Date: 2022.08.31

RE: Commentary Response per Permit No. 2112-250

This letter is in regards to your THIRD review of the proposed single-family residence. Please see below for a response to your commentary in italics and our responses in bold. Thank you.

**UPPER FLOOR & LOWER ROOF FRAMING PLAN**  
SCALE: 1/4" = 1'-0"

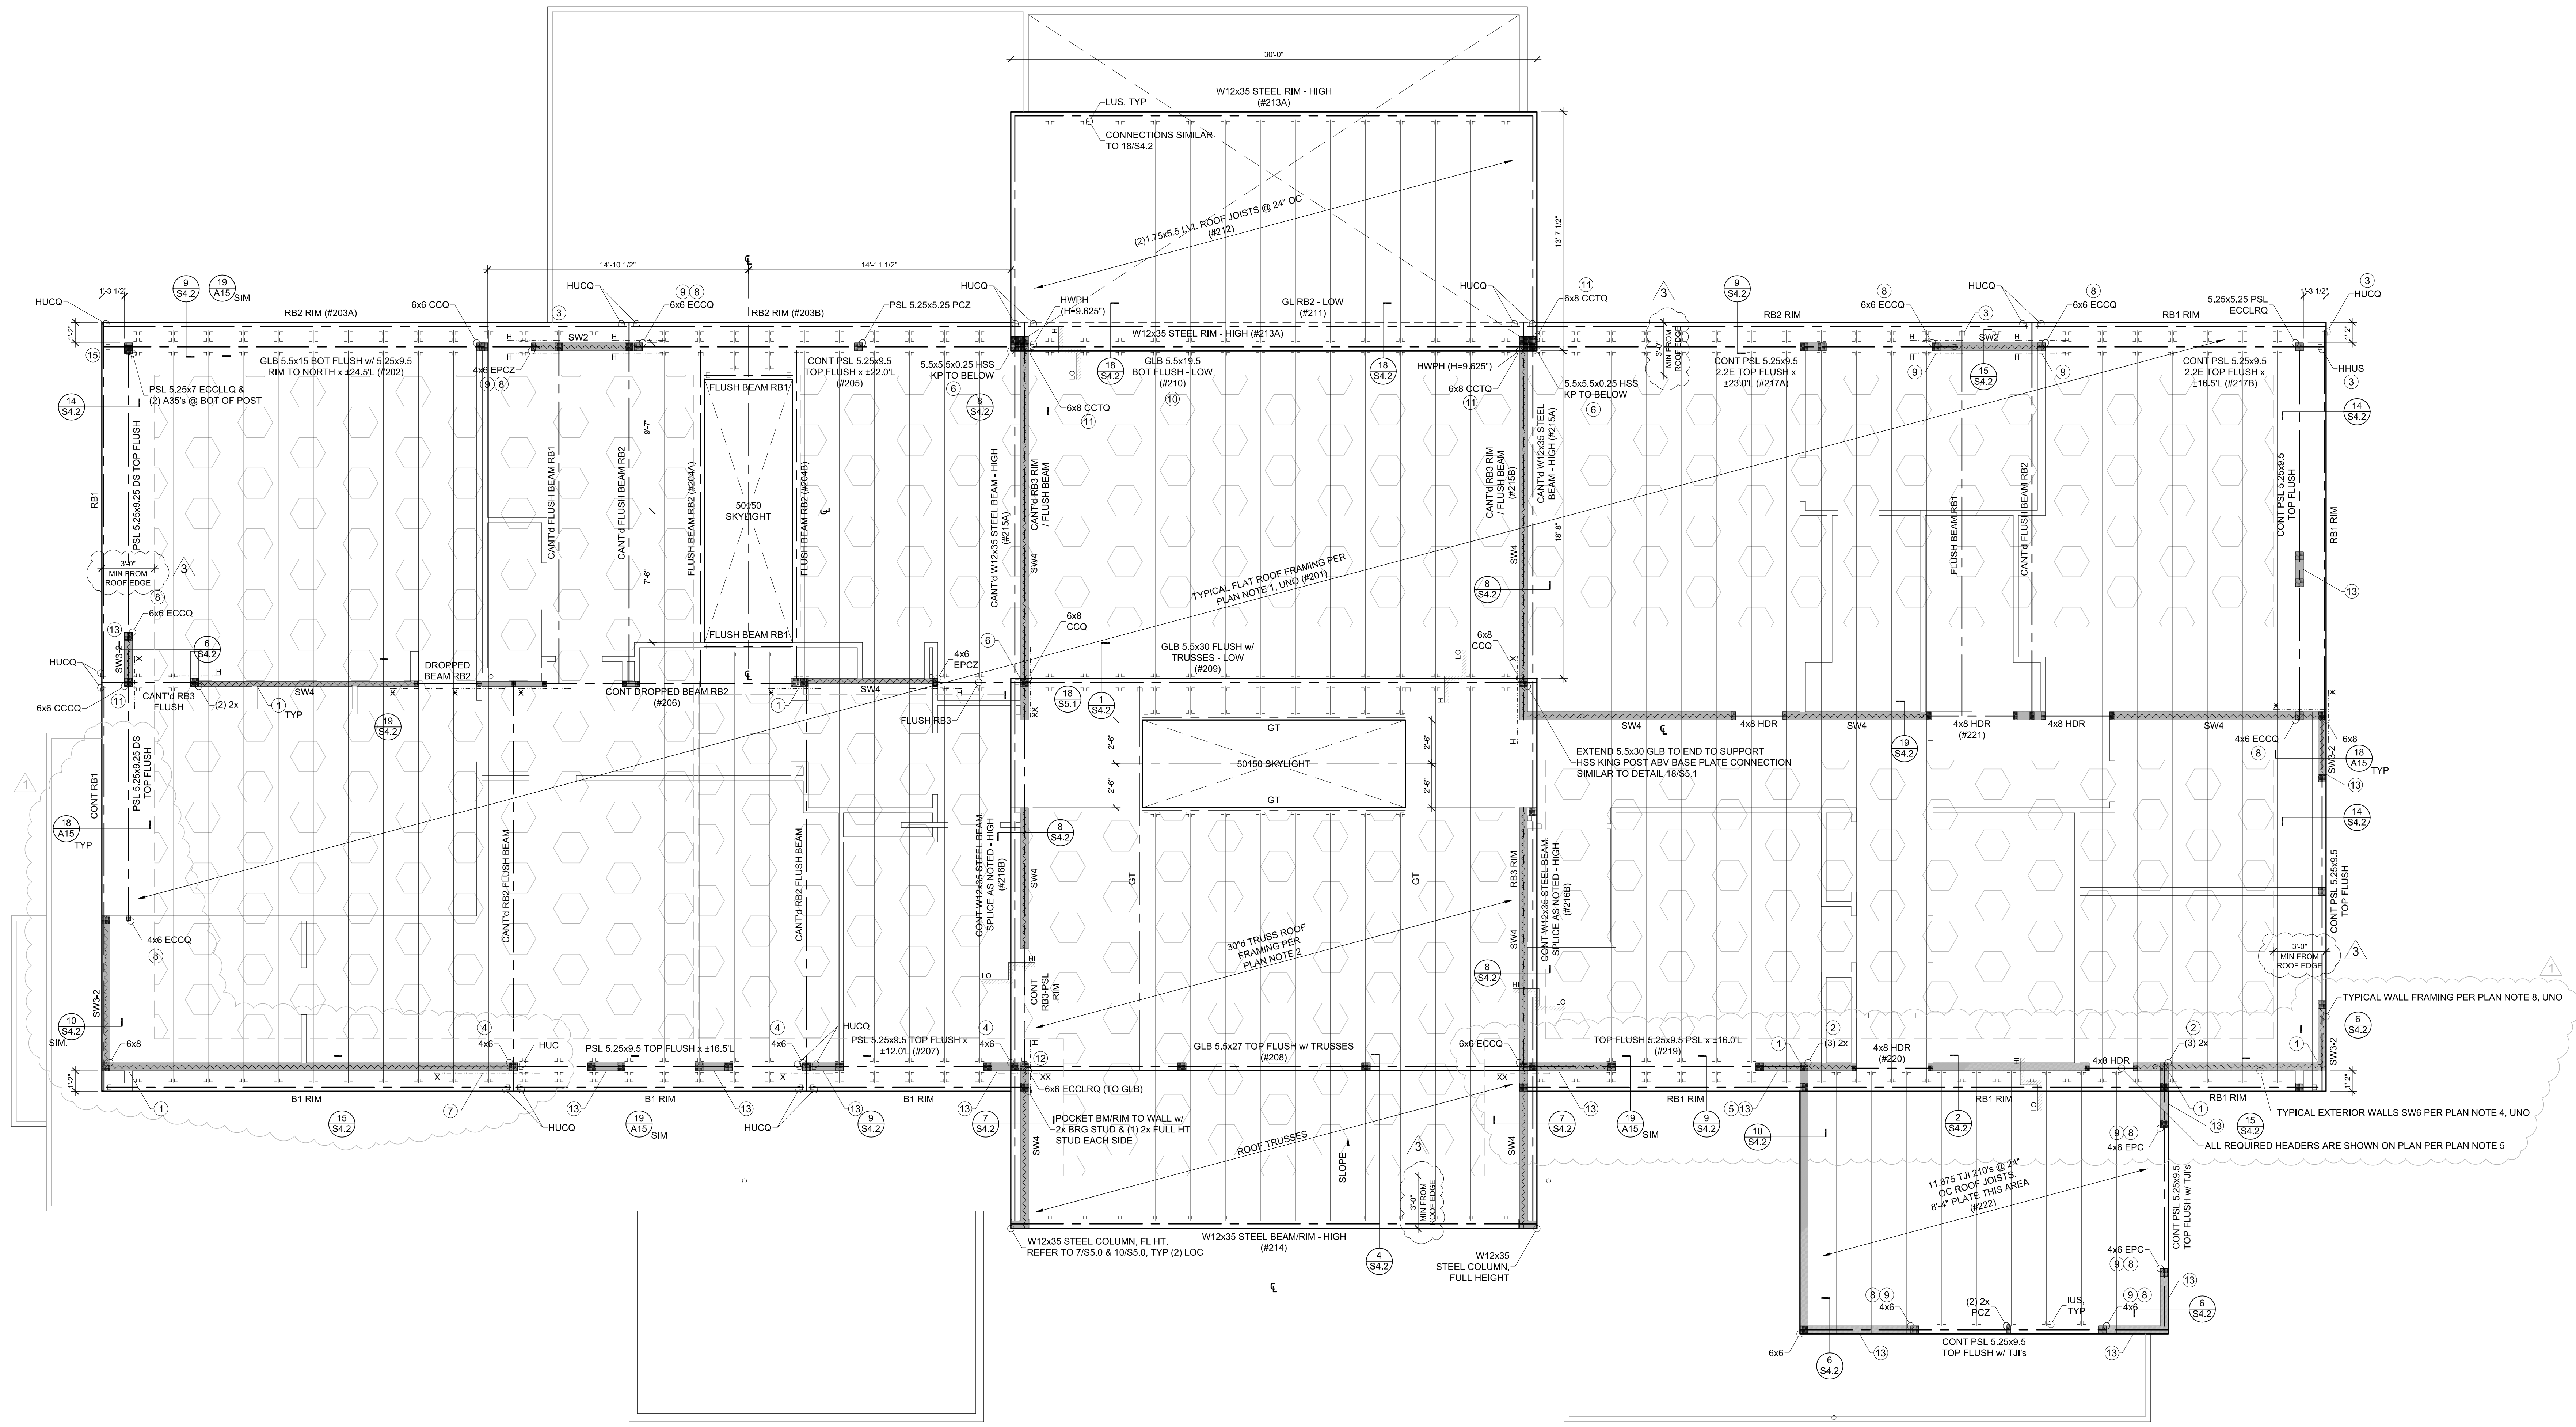
2. *Page 16 of 16 of the solar design documents has a roof plan that shows the panel layout, the same area is hatched on Sheet A8 to show location of the panel arrays. Page 4 of 16 of the solar design documents notes the wind design requires the module edge be a minimum of 3' from the building edge. This does not appear to have been provided. Please add this dimension to Sheet A8 and verify that the panel design will fit on the roof considering this limitation.*

- a. **Revised. Dimensions have been provided on Sheet A8 demonstrating a minimum 3' distance from the edge of building. Additional dimensions have been provided on solar documents page 16 of 17.**
